**CITY OF ALBUQUERQUE
PLANNING DEPARTMENT
April 9, 2008
DRB Comments**

PROJECT # 1006001 APPLICATION # 08-70161

RE: Tract 22, Mesa del Sol Innovation Park

PLAT OF  
**TRACTS 22-A, 22-B & 22-C**  
**MESA DEL SOL**  
**INNOVATION PARK**  
 (A REPLAT OF TRACT 22  
 MESA DEL SOL INNOVATION PARK)  
 ALBUQUERQUE, BERNALILLO COUNTY, NEW MEXICO  
 JANUARY, 2008

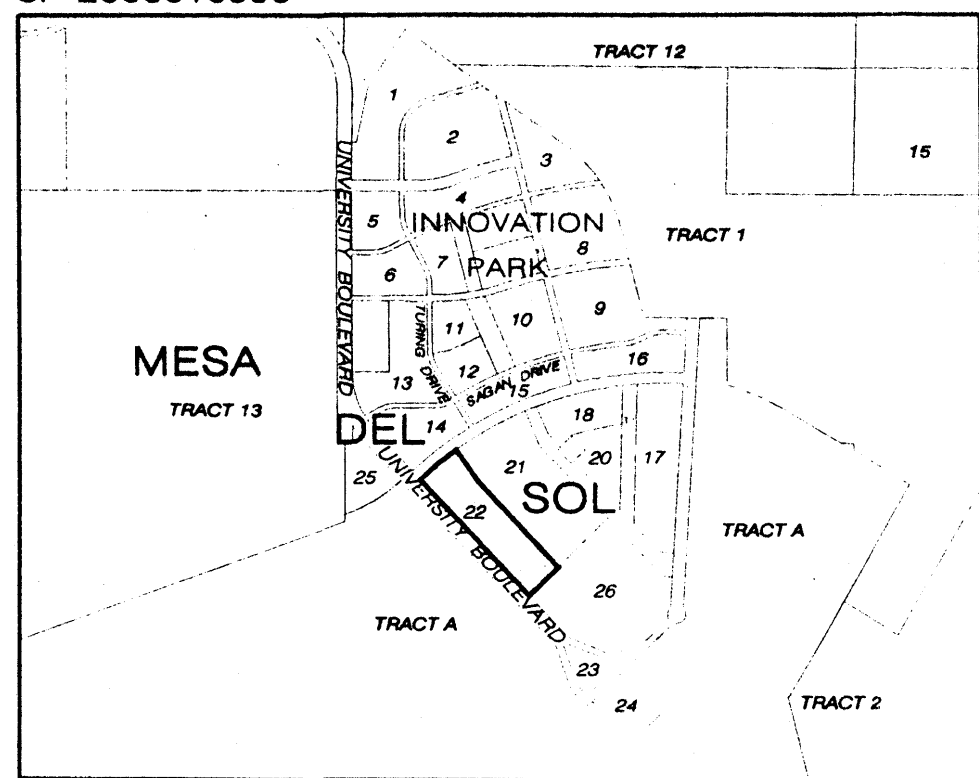
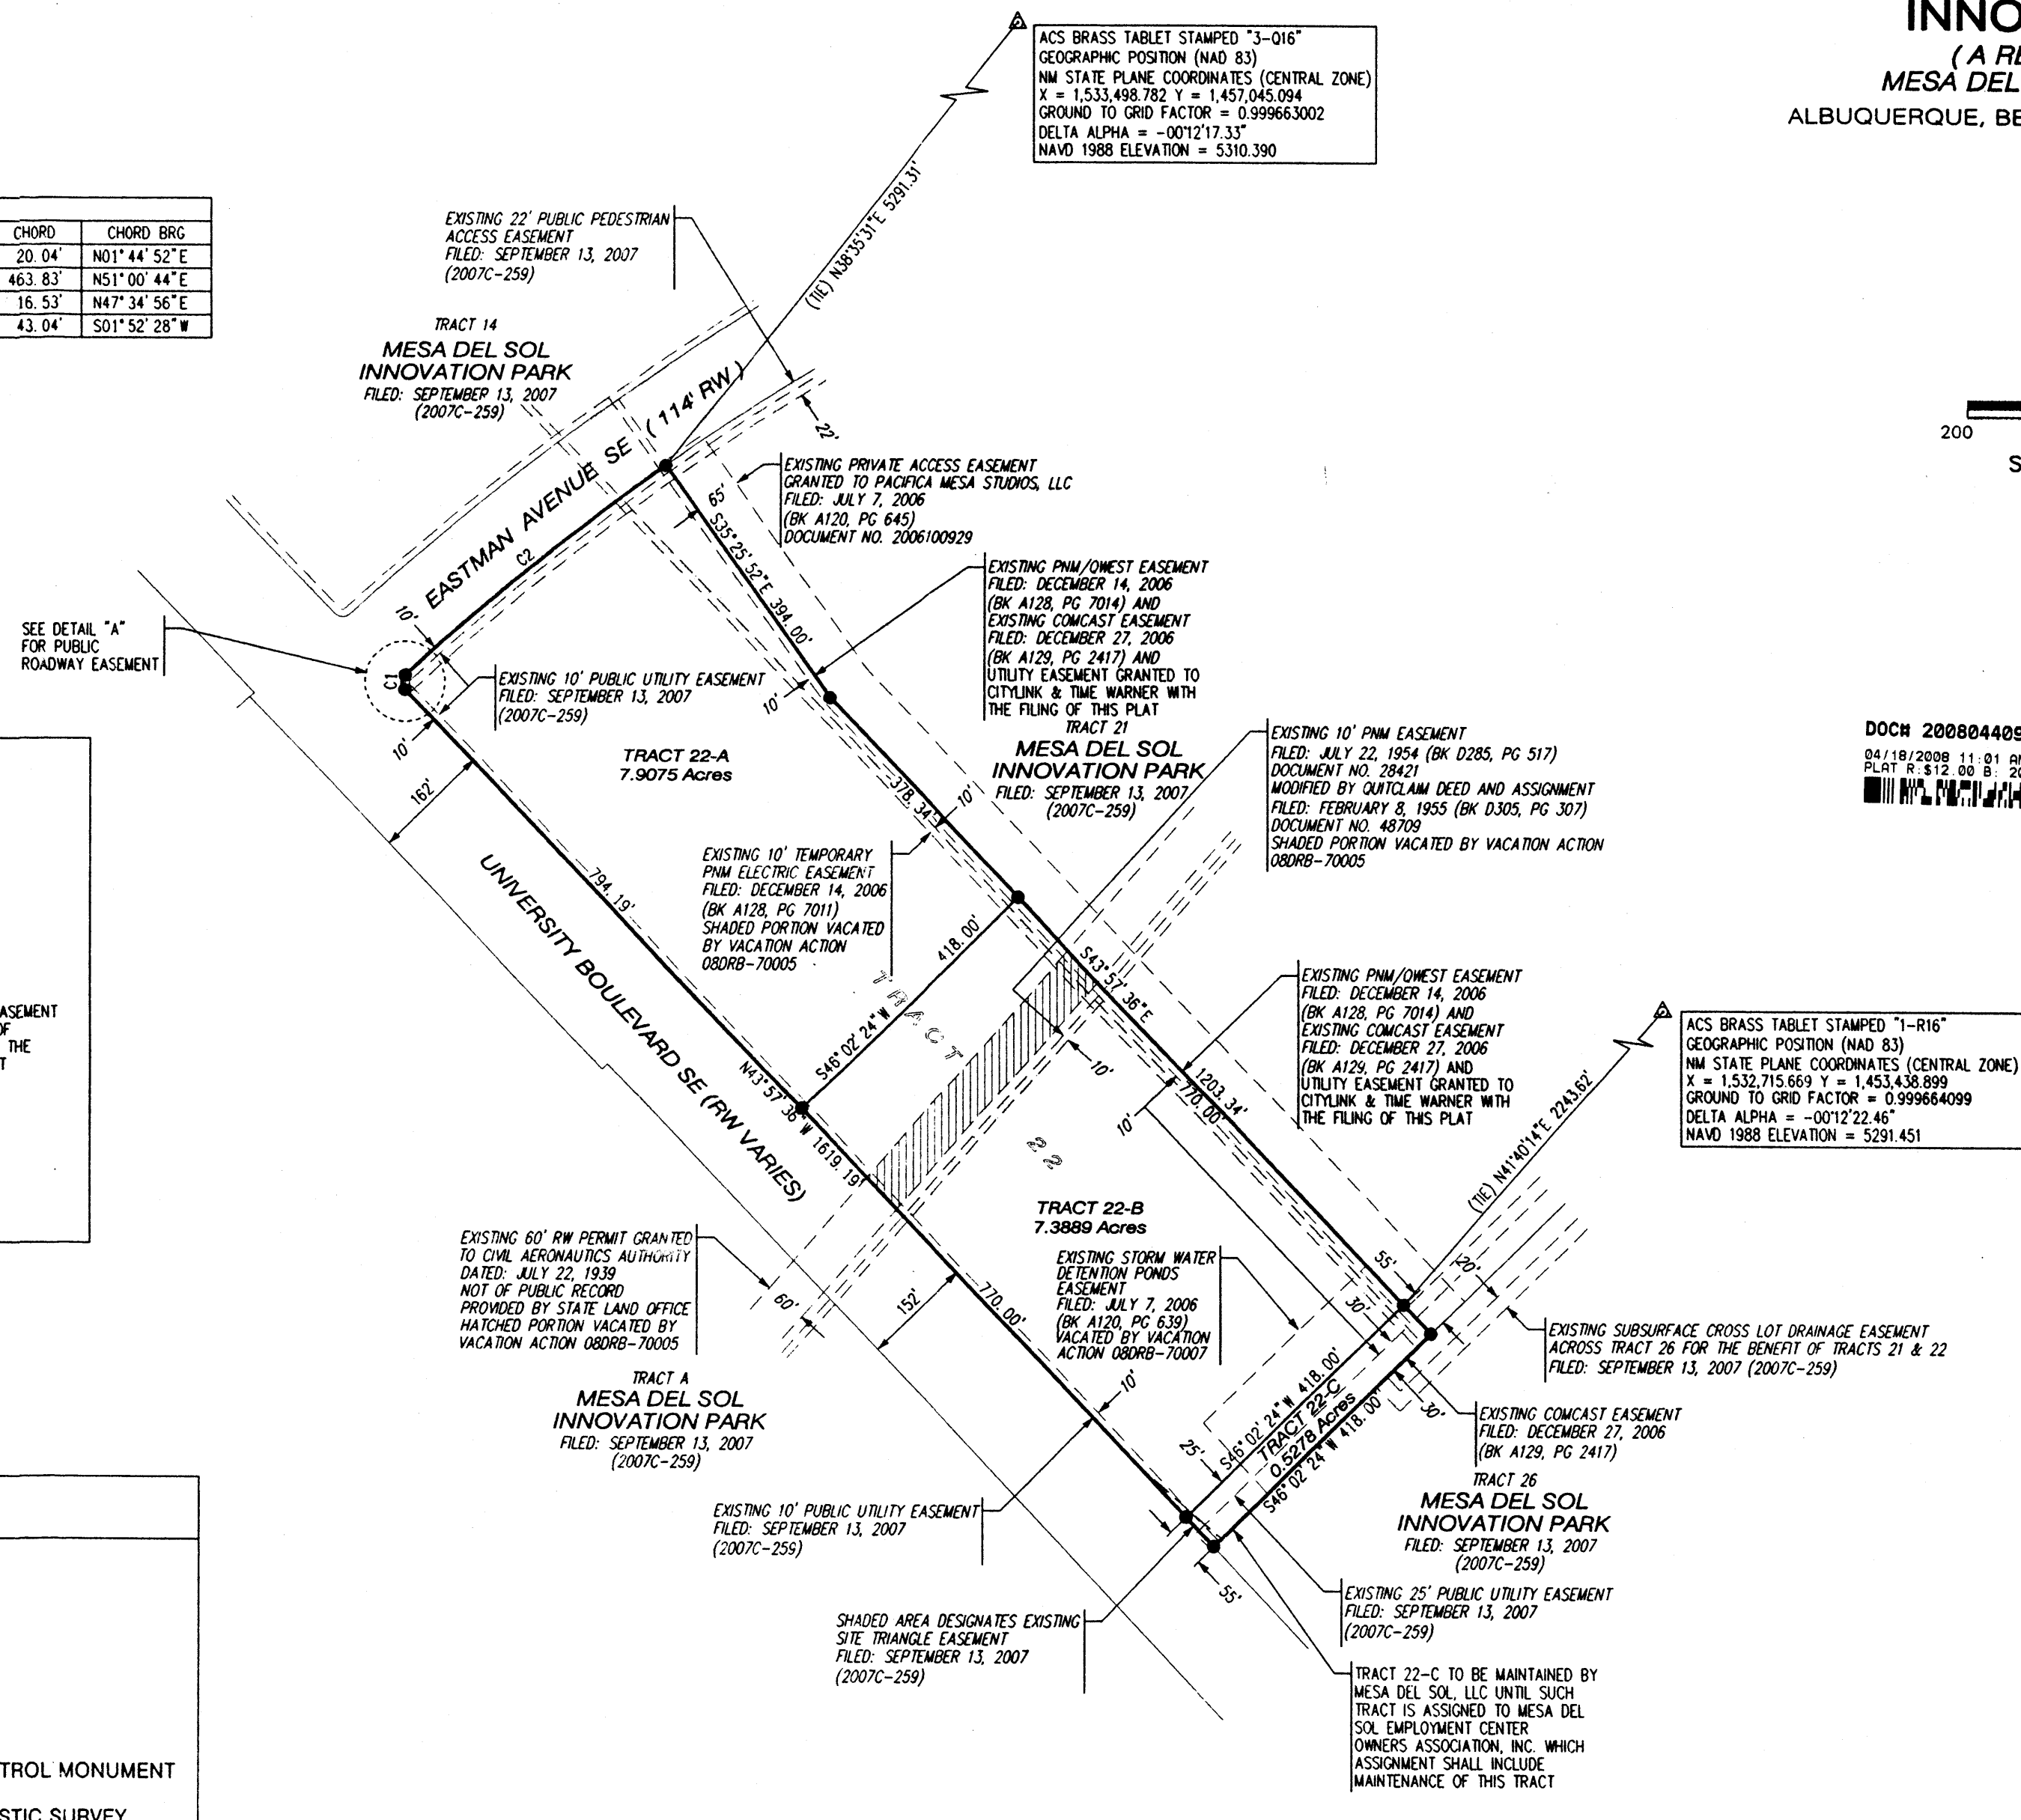
Maintenance of proposed Tract 22-C must be addressed per the Subdivision Ordinance prior to final sign-off.

For future reference, please do not identify the property's zoning (Note 3) on the plat. Also, please revise solar note to be specific to this type of request, i.e. use the words "THIS PLAT" and not "REQUESTED FINAL ACTION" and do not use the words "OR SITE DEVELOPMENT PLAN FOR SUBDIVISION" at the end of the note.
